**Planning Department
Transportation Development Services**

October 26, 2015

**Re: Foods of New Mexico Warehouse
3041 University Blvd.
Traffic Circulation Layout**
Architect's Stamp dated 10-1-15 (M15-D023C)

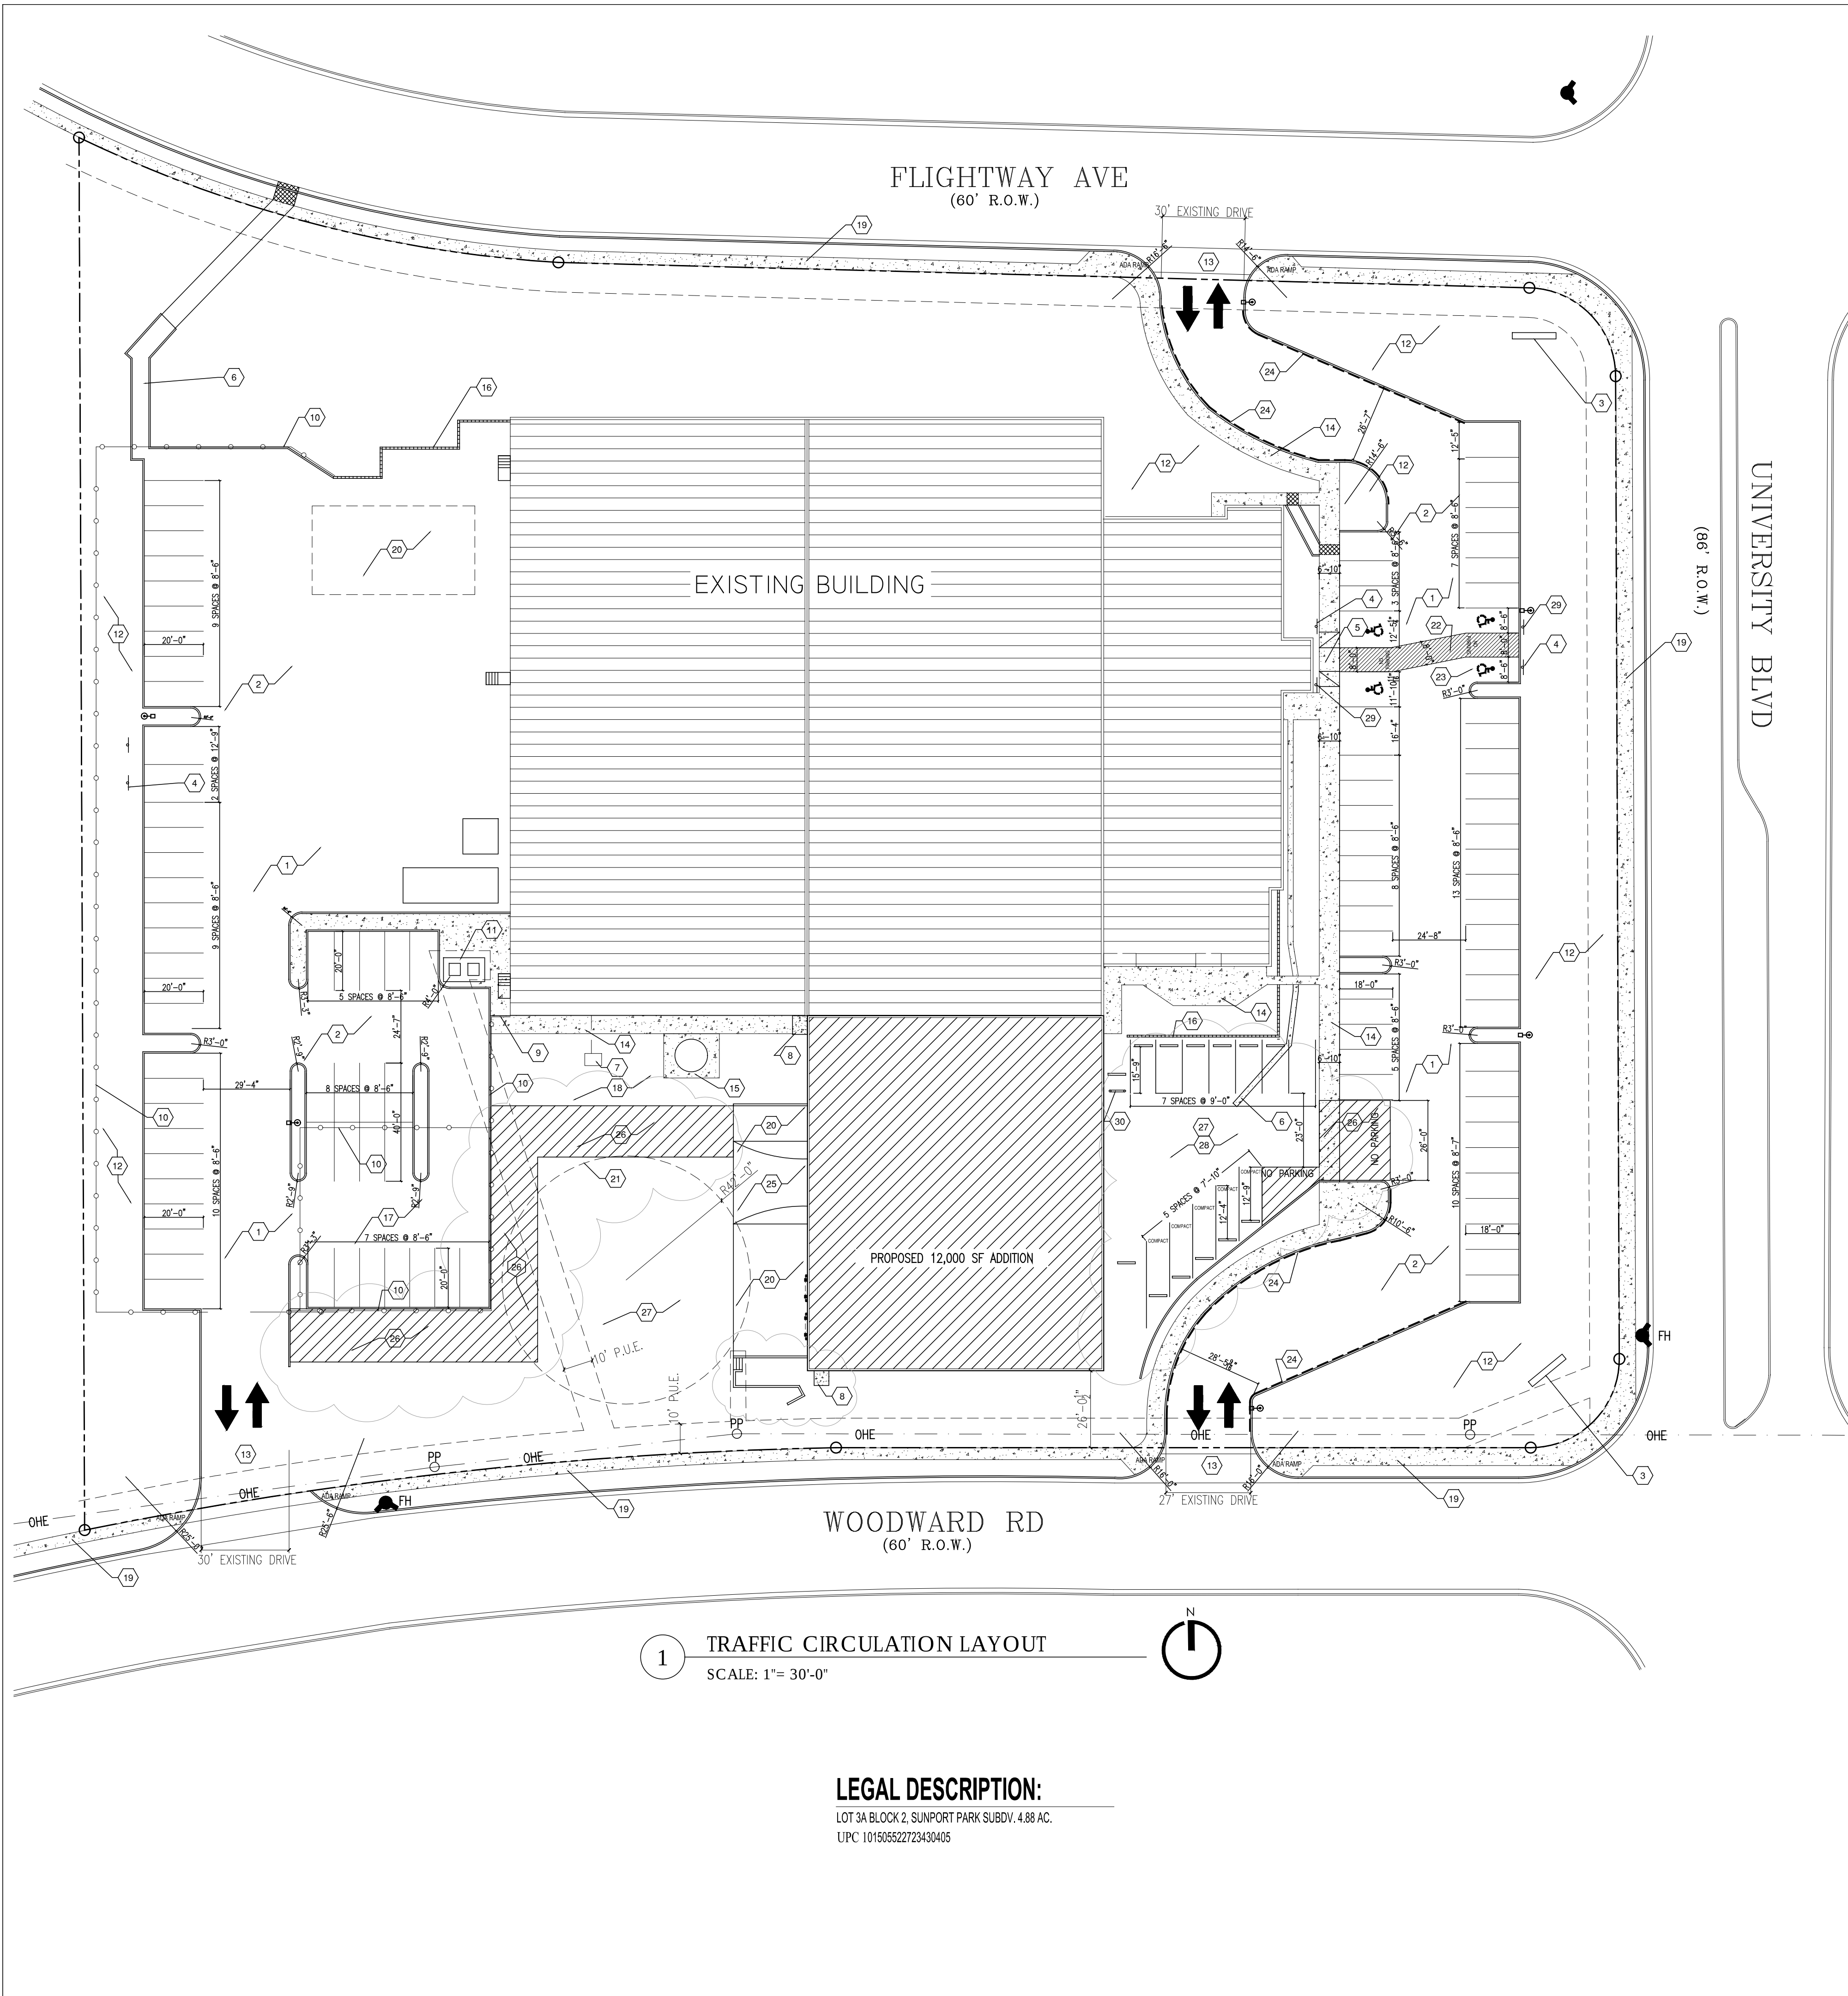
1. Identify the right of way width and street width on University.
2. Please list the width and length for all existing parking spaces.
3. The handicap accessible spaces must be a minimum of 8.5 feet in width.

4. The handicap accessible spaces must include an access aisle 8 ft. wide van accessible space; the other aisles should be 5 ft. in width.
5. The ADA accessible parking sign must have the required language per 66-7-352.4C NMSA 1978 **"Violators Are Subject to a Fine and/or Towing."** Please show a detail of existing ADA signage.

6. The ADA access aisle shall have the words **"NO PARKING"** in capital letters, each of which shall be at least one foot high and at least two inches wide, placed at the rear of the parking space so as to be close to where an adjacent vehicle's rear tire would be placed. (66-1-4.1.B NMSA 1978) Please show this detail on drawing.

7. Show all drive aisle widths and radii.
8. Per the DPM, a 6 ft. wide ADA accessible pedestrian pathway is required from the HC parking stall access aisles to the building entrances. Please detail dimension of existing ADA pathway.
